Re: Status of Improvement Permit Application #05-5-11770

On April 5, 2005, an Environmental Health Specialist from the Harnett County Health Department attempted to evaluate your property for the purpose of issuing an Improvement Permit. This individual was unable to evaluate your property for one or more of the following reasons.

SITE PLAN APPROVAL

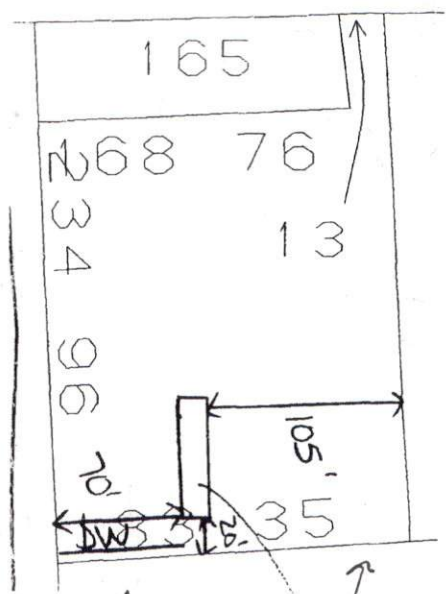
- 1. Property lines/corners not marked or labeled
- 2. House corners not marked or labeled
- 3. Directions not clear to property
- 4. Property needs brush or vegetation removed
- 5. Backhoe pits required
- 6. Other **Change house location as shown. Submit changes to Central Permitting.**

Changes need to have
location - New home site
Flagged by me (Joe West)
